# Rezoning Transportation Analysis

Petition Number: 2023-007

## Revision Log:

Date	Description
05-23-2023	First Review (JP)

SHEET TITLE
REZONING PLAN: PETITION # 2023-007

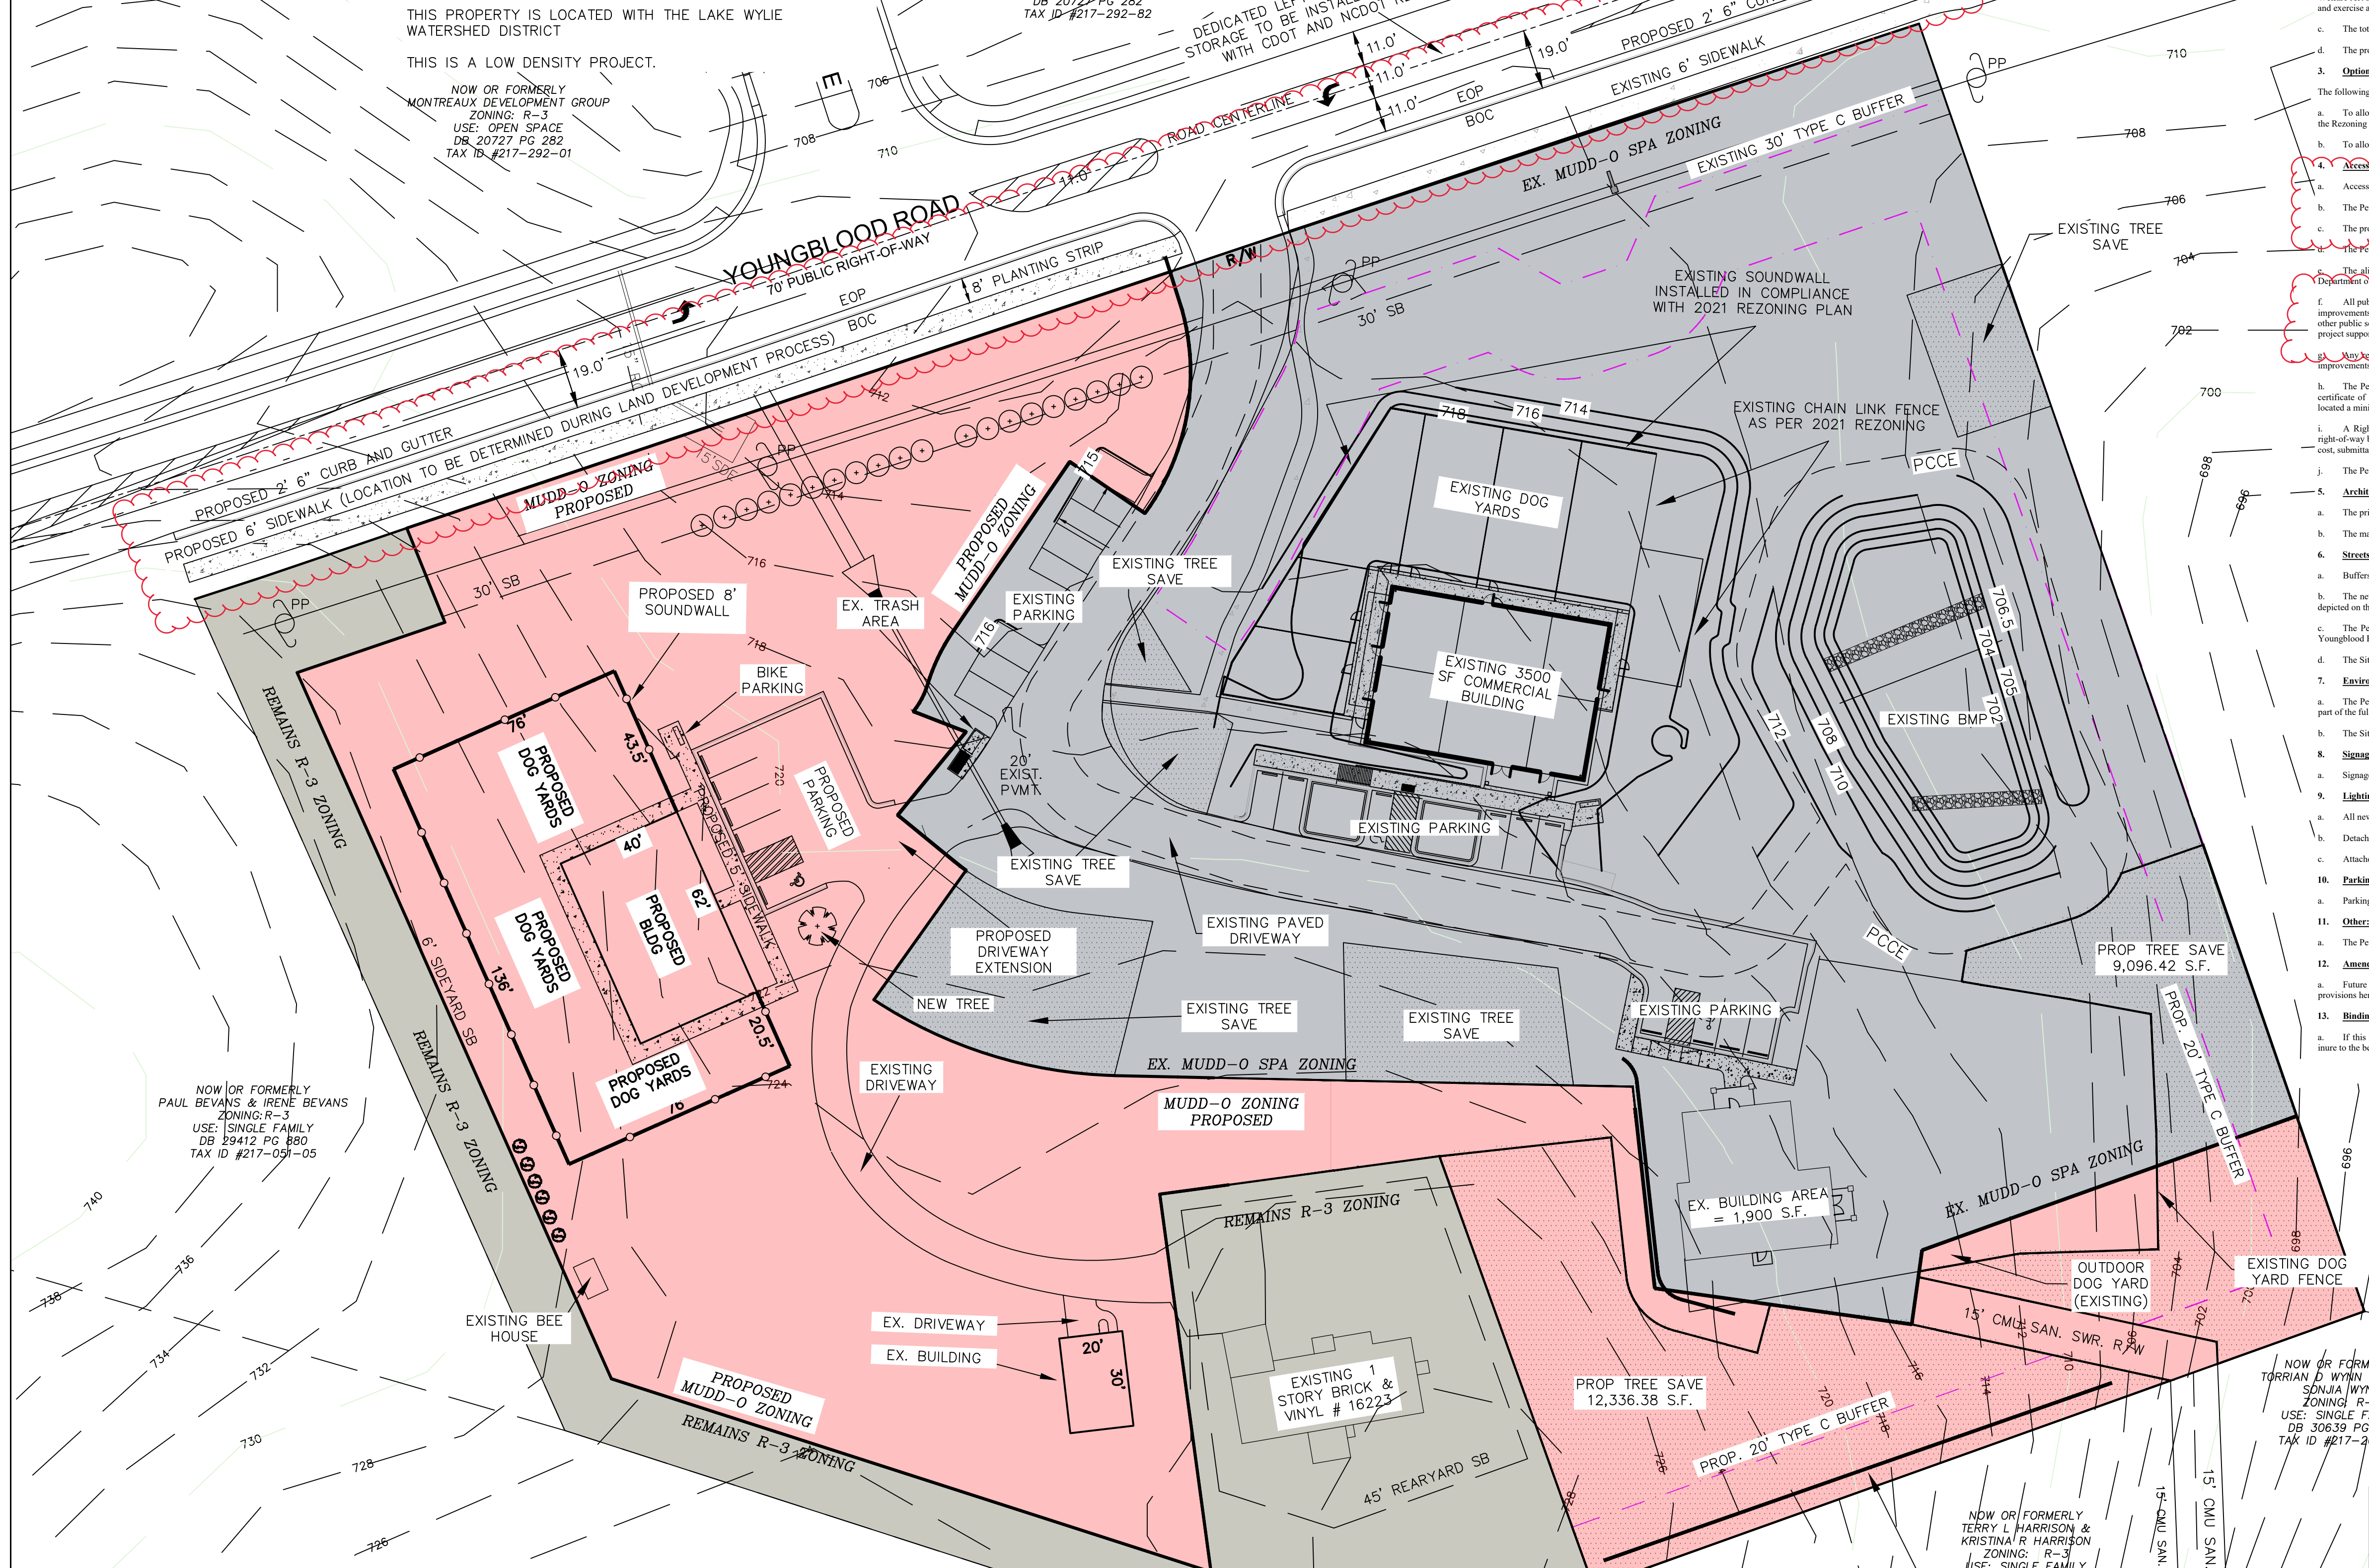
- Youngblood Road:** Location of curb and gutter to be moved to 19 feet from roadway centerline to accommodate the Charlotte Streets Map with a roadway typical section of a 2+ avenue with an 8 foot planting strip and a 12 foot multi-use path.

Label and dimension the curb and gutter from the centerline for each road on the site plan.

- Revise site plan and conditional note(s) to commit to construct bicycle facilities by installing a 12' multi-use path to meet the Council-adopted Charlotte BIKES Policy. Multi-use paths maintained by the City shall meet ADA/PROWAG requirements.

5. Revise site plan and conditional notes to provide a minimum of 35ft of ROW to the roadway centerline of Youngblood Road if it does not exist. Label and dimension the ROW.

6. Revise site plan and conditional note(s) to commit to installing a left turn lane on Youngblood Road with 100 feet of storage.
7. Add a conditional note specifying "the Petitioner shall dedicate and convey in fee simple all rights-of-way to the City before the site's first building certificate of occupancy is issued. CDOT requests rights-of-way set at 2' behind back of sidewalk where feasible."

10. Revise site plan and conditional note(s) to construct 8-foot planting strips and 12-foot multi-use path on Youngblood Road. The site plan shall label and dimension both items from the back of curb and gutter. Add conditional note The entire facility must be outside of the right of way and within a public access easement. Add conditional note committing to construction and maintenance of the 12-foot multi-use paths on Youngblood Road.
